From:
Sent: 13 November 2025 18:21
To: Louise Bearcroft; DC Admin; Waste Planning
Subject: Objection to Planning Applications 2025/61/92713/E and 2025/44/92737E - -Moor Lane, Gomersal

Objection to Planning Applications 2025/61/92713/E and 2025/44/92737E

Bin Collection Points and Bin Drag Distances

HOUSE TYPE 03

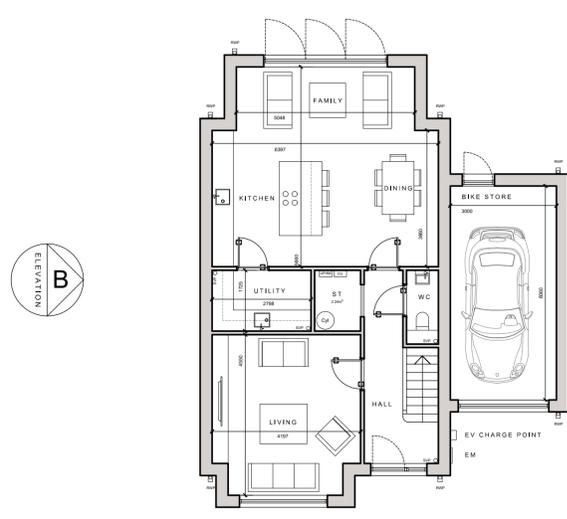
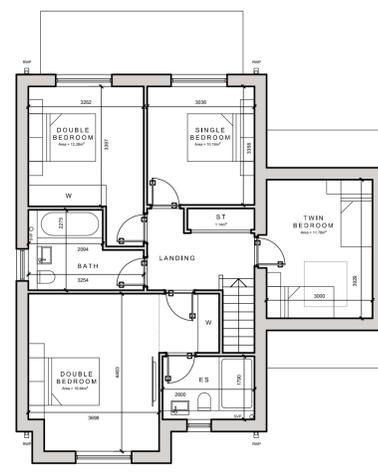
Plot 10 (HT05)	Width 7310	Depth 11389	Garage Width 3000	Pathways width	????					
Plot 9 (HT03)	Width 6397	Depth 11935	Garage Width 3000	“““	“““	“““				
Plot 8 (HT03)	“““	“““	“““	“““	“““	“““	“““	“““	“““	“““
Plot 7 (HT03)	“““	“““	“““	“““	“““	“““	“““	“““	“““	“““

HOUSE TYPE 05

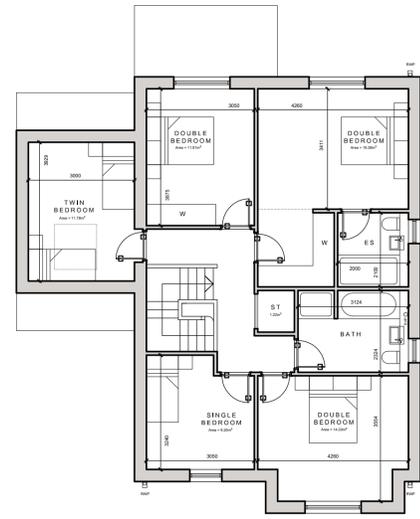
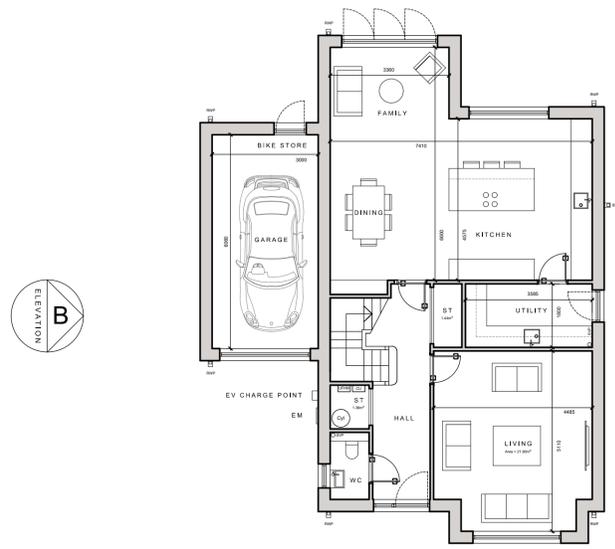
Plot 10 - minimum 57 metres (excluding pathway widths)

Client PPU Developments
Project 2539 - Moor Lane - Residential
Title Proposed Site Plan
Drawing Number

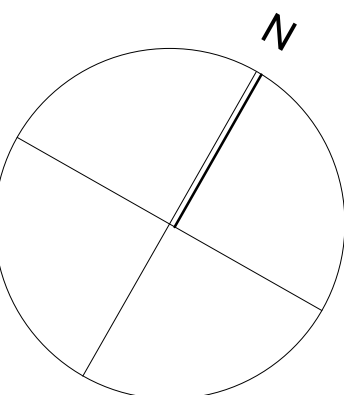
Plot 7, 8 9 and 10 are located down a private drive which will mean residents will have to drag their bins to the bin collection point, located at the end of the private drive.

The drags distance for plot 8, 9 and 10 all exceed this maximum 25metre.

Plot 9 - minimum 34 metres (excluding pathway widths)

Plot 8 - minimum 27.5 metres (excluding pathways widths)

Plot 7 - minimum 18 metres (excluding pathways widths)

Therefore only Plot 7's drag distance is below the maximum allowable drag distance of 25 metres and Plots 8,9 &10 all exceed the maximum allowable drag distance.
